From: Anita Gardner
Sent: 17 July 2018 18:11
To: Planning.Responses
Subject: FW: FG/64/18/DOC

From: Liz Hutchings [REDACTED]
Sent: 17 July 2018 18:09
To: Anita Gardner
Subject: FG/64/18/DOC

Further to the video I sent you last week, I have just read Ian Haywards consultation letter 17.07.18 and his recommendation to approve the traffic light system.

Figure 3: Traffic Signal System (Example of Signal Head)

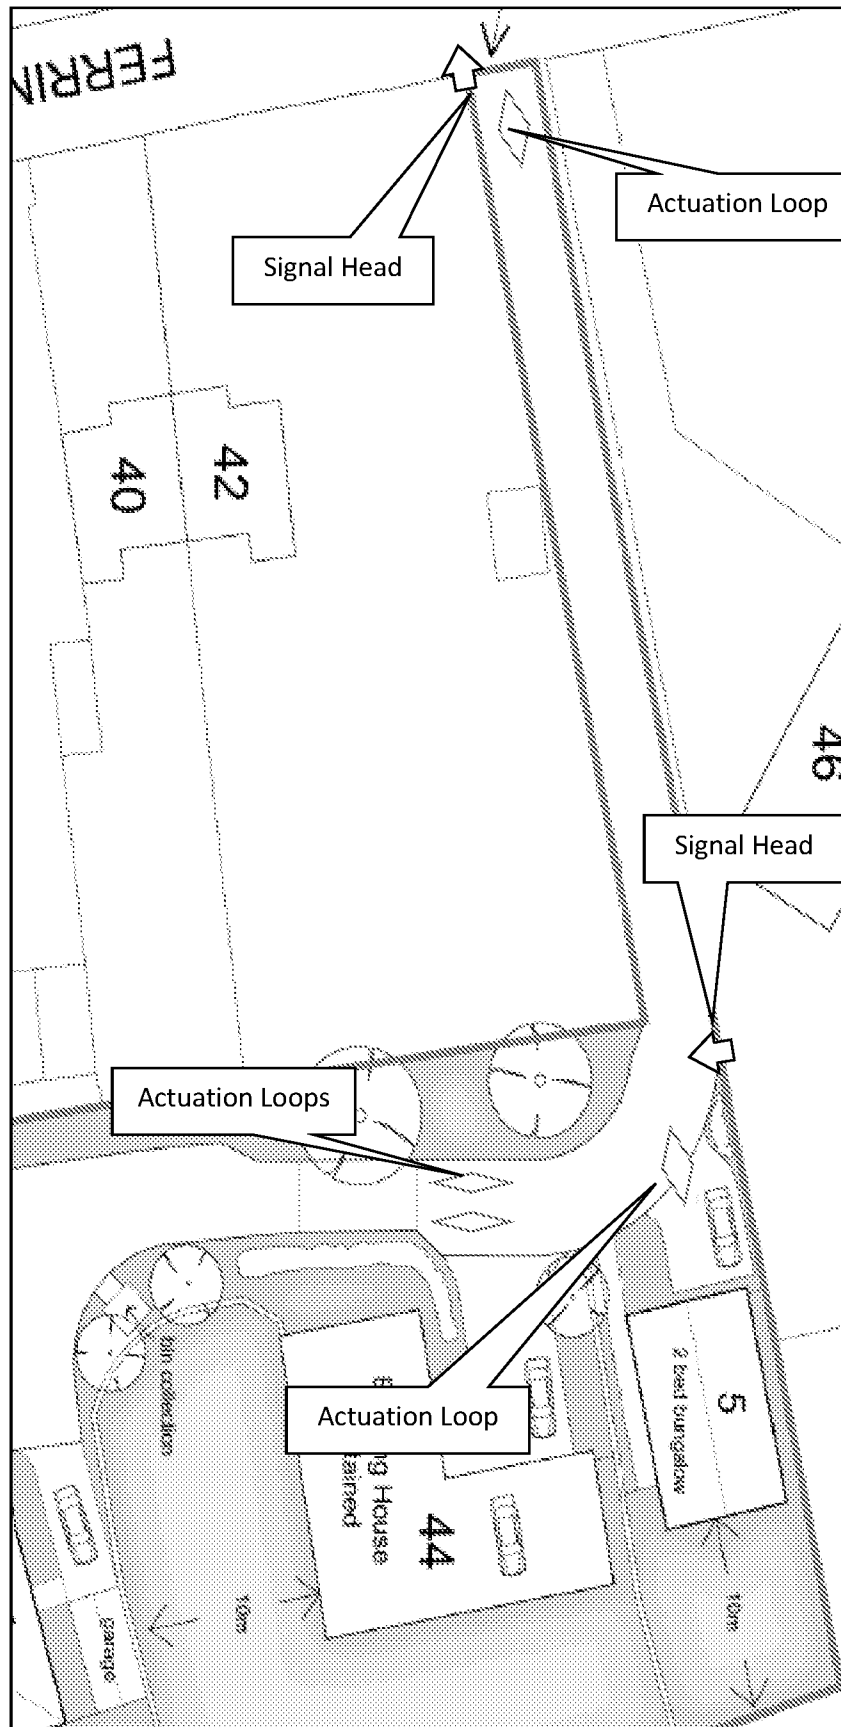
However there is still no proper illustration to show how it would look when erected. They say it is wall mounted (this of course is to be on a pole, mounted on the wall at the street end ,(in a street where we don't want or have street lighting), I wonder what the Parish Council views are on this? Or indeed the Ferring Roads or Residents Association? Would you be able to intercede?
